**From:** Christopher Ashworth [REDACTED]  
**Sent:** Wednesday, 24 May 2017 12:25 PM  
**To:** Pilar Aberasturi  
**Cc:** Amy Watson; Brendon Roberts; Bill MacKay  
**Subject:** Section 96 Modifications to the Australian Technology Park, Eveleigh (SSD 7317 MOD 1 and MOD 2)

**NOTICE OF SECTION 96 MODIFICATIONS TO THE AUSTRALIAN TECHNOLOGY PARK, EVELEIGH (SSD 7317 MOD 1 AND MOD 2)**

**OUR REF: R/2015/37/C**

TOTAL CAR SPACES:
Lower Ground (93 spaces) + Mezzanine (60 spaces) + Upper Ground (64 spaces) = 217 car spaces

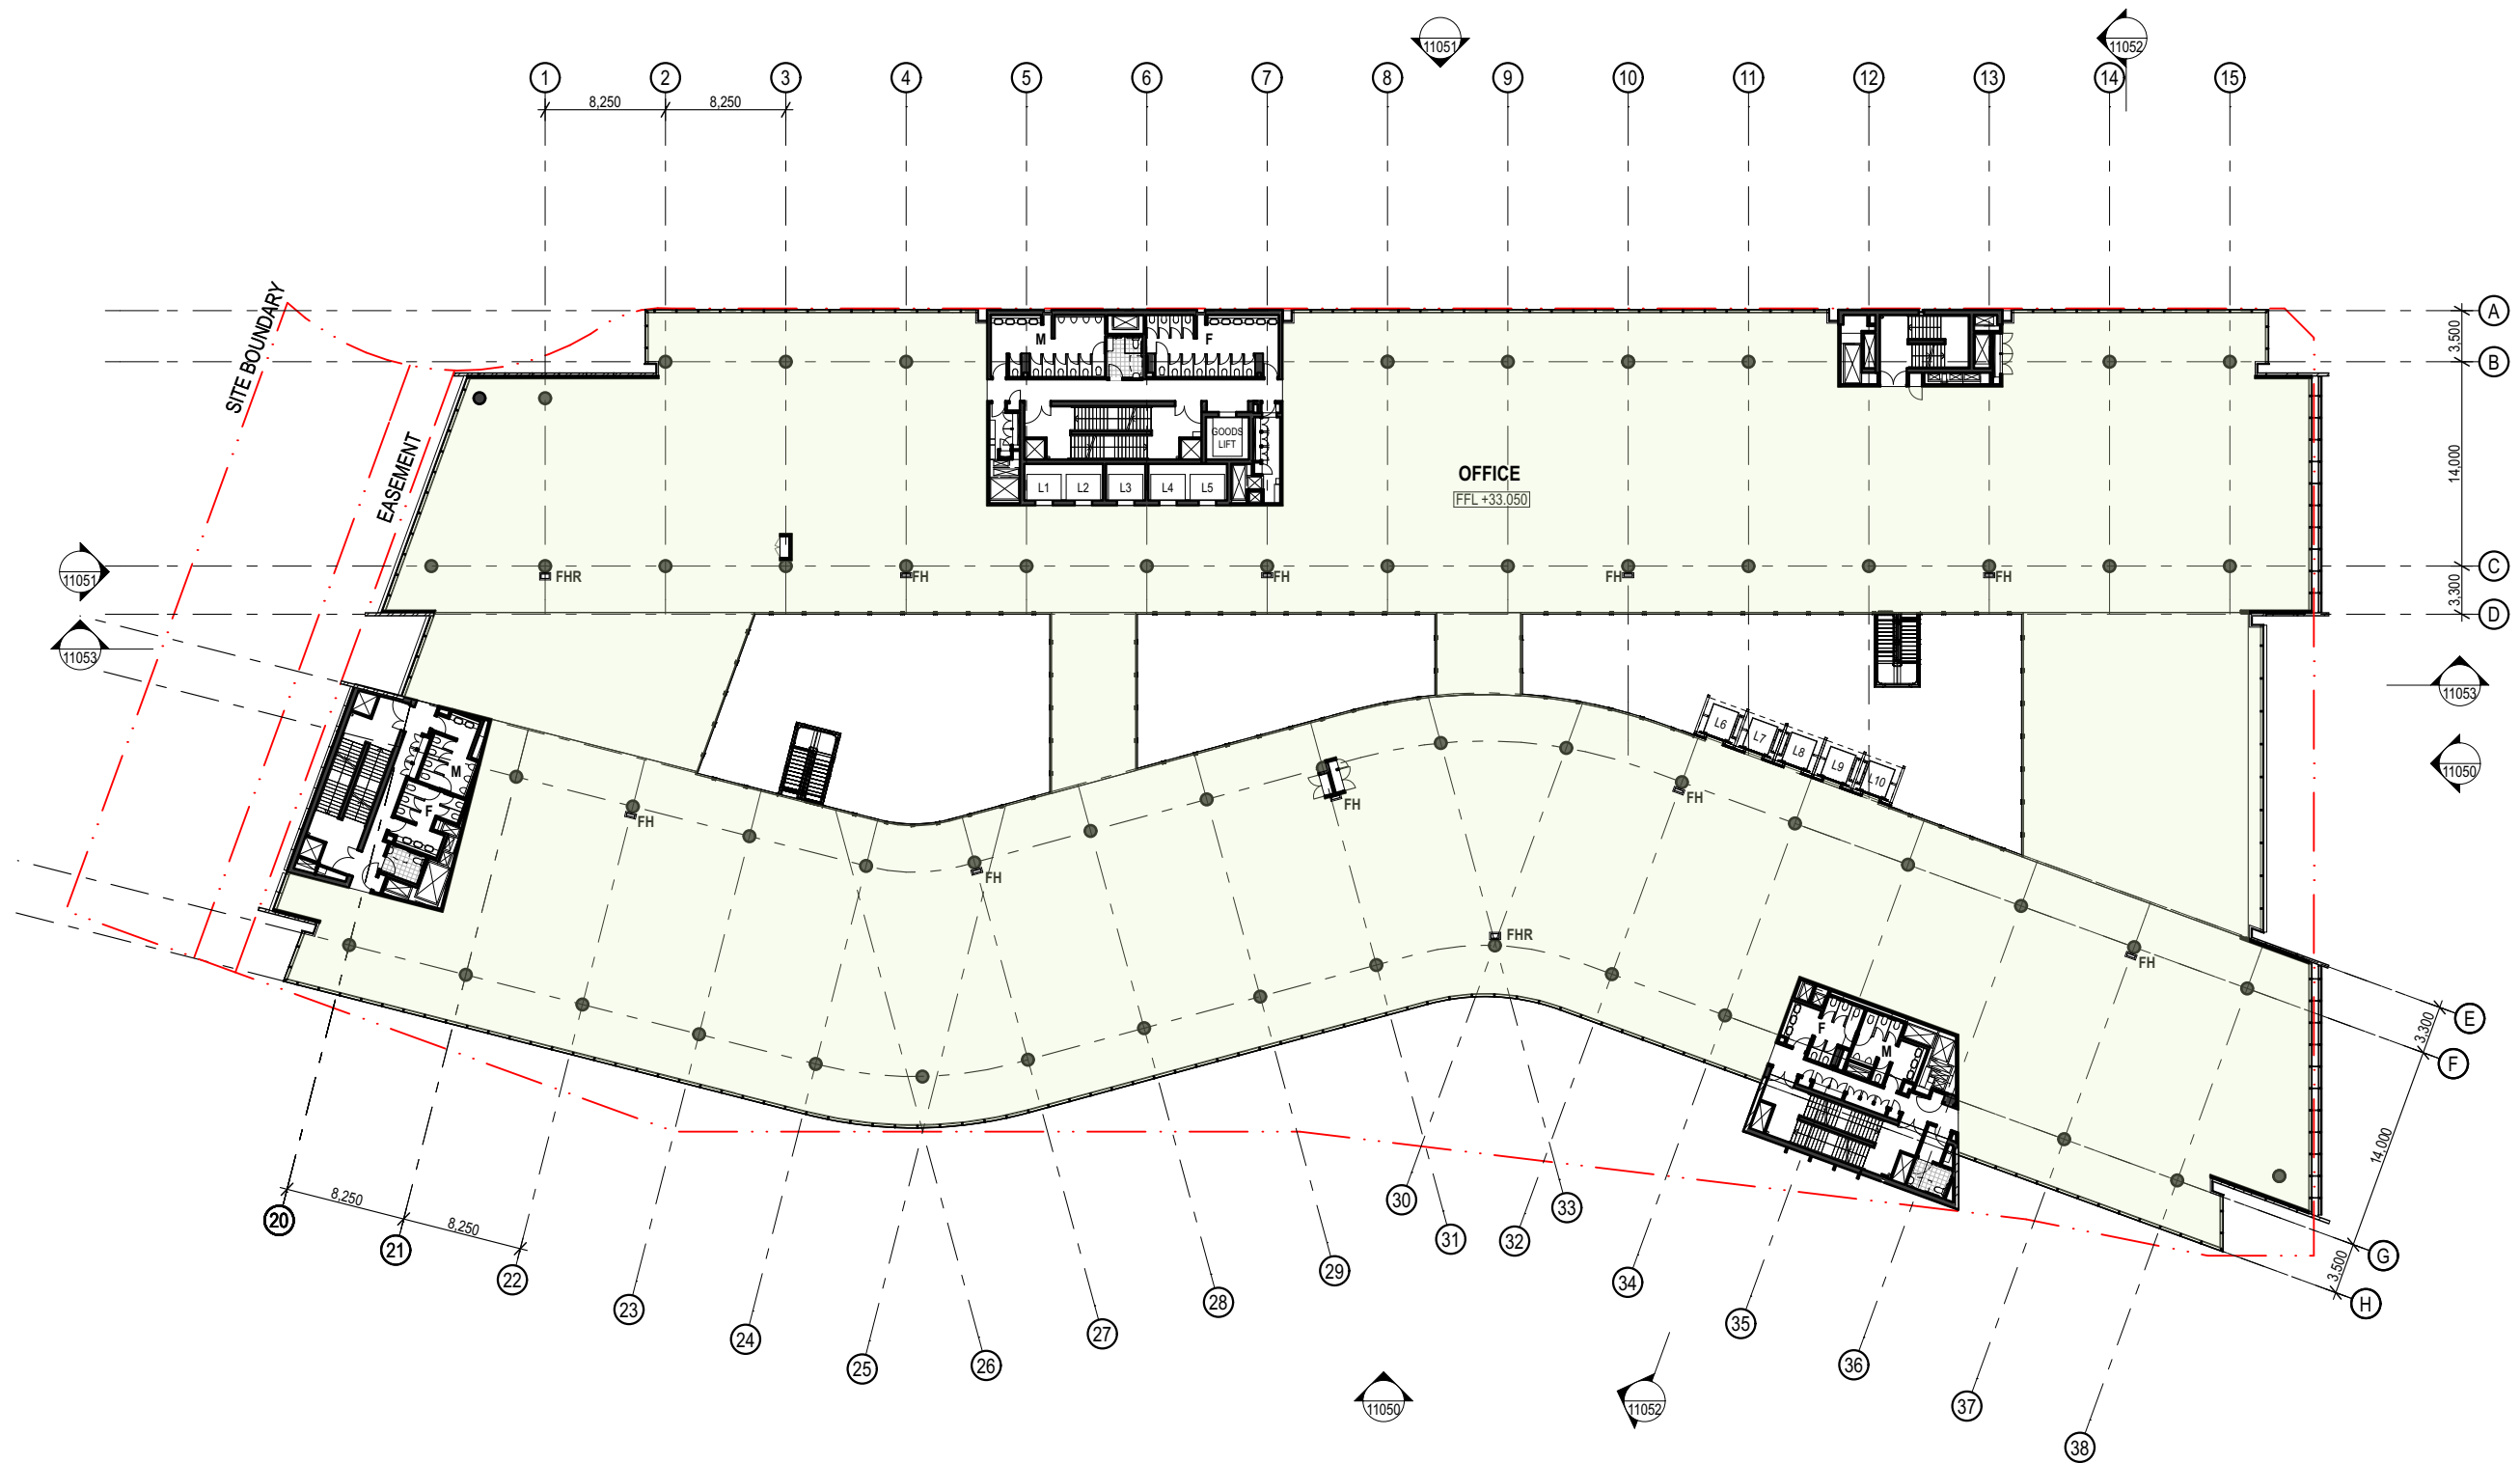
The City also objects to the deletion of secure bicycle parking from the basement areas.
